RE: **Volcano Cliffs Subdivision Lot 1, Block 8, Unit 18**
6512 Papagayo Rd. NW
Grading and Drainage Plan
Engineers Stamp Date 1/30/17 (D10D003O1)

DRAINAGE AND TRANSPORTATION INFORMATION SHEET (REV 09 2015)

Project Title: 6512 Papagayo Rd NW G+D Building Permit #: _____ City Drainage #: _____
DRB#: _____ EPC#: _____ Work Order#: _____
Legal Description: Lot 1 Block 8 Unit 18 VCS
City Address: 6512 Papagayo Rd NW ABA NM 87112
Engineering Firm: Wilson & Company Contact: Steve Metro
Address: 4900 Long Ave NE ABA NM 87109
Phone#: 505-280-4553 Fax#: 505-348-4055 E-mail: steve.metro@wilsonco.com
Owner: American Home Realty Contact: Mia Huynh
Address: 1912 San Breyse St NW
Phone#: 505-440-4632 Fax#: _____ E-mail: mhuynh@comcast.net
Architect: _____ Contact: _____
Address: _____
Phone#: _____ Fax#: _____ E-mail: _____
Other Contact: _____ Contact: _____
Address: _____
Phone#: _____ Fax#: _____ E-mail: _____

GRADING AND DRAINAGE PLAN
LOT 1, BLOCK 8, UNIT 18, VCS
ADDRESS: 6512 Papagayo Rd NW

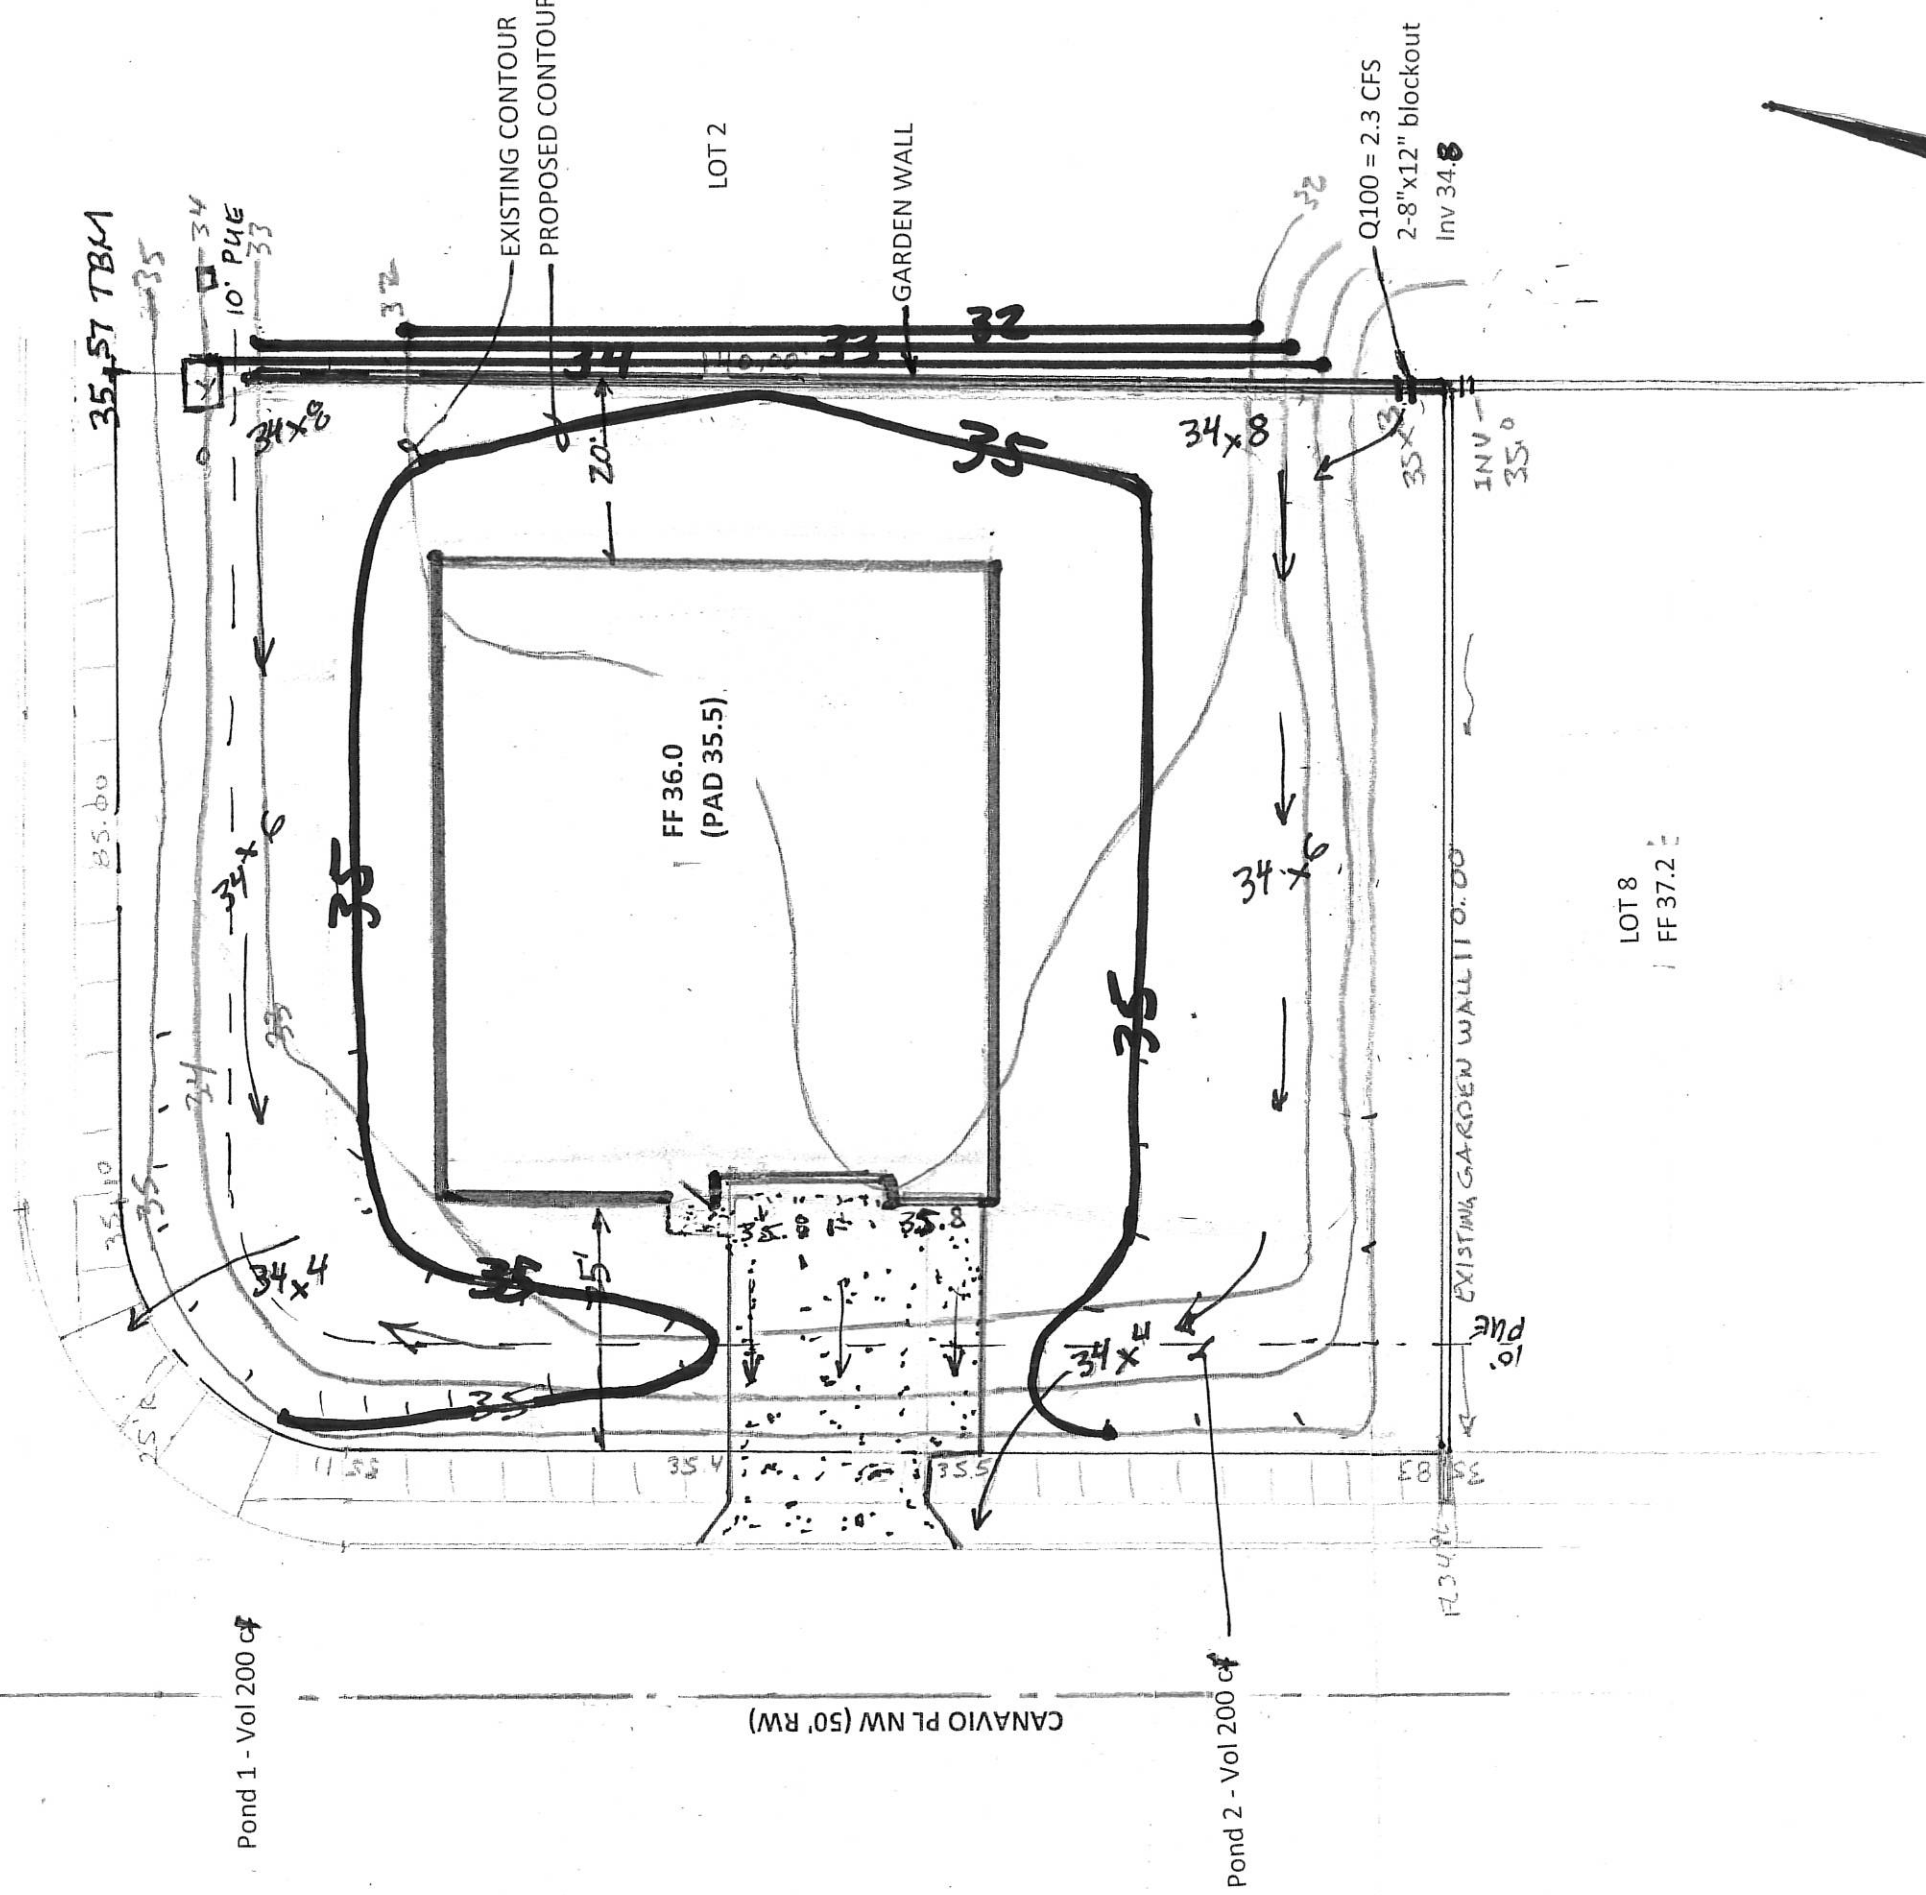
- Provide a note stating that future garden walls require a separate permit and this plan should be used for their placement.
- Also state that future garden walls require an opening 3" above grade in the SW corner.
- Provide a statement that a pad certification is required before a building permit is given.

- Note:
1. Future garden walls require a separate permit and this plan should be used for their placement.
 2. Future garden walls require an opening 3" above grade in the SW corner.
 3. A pad certification is required before a building permit is given.
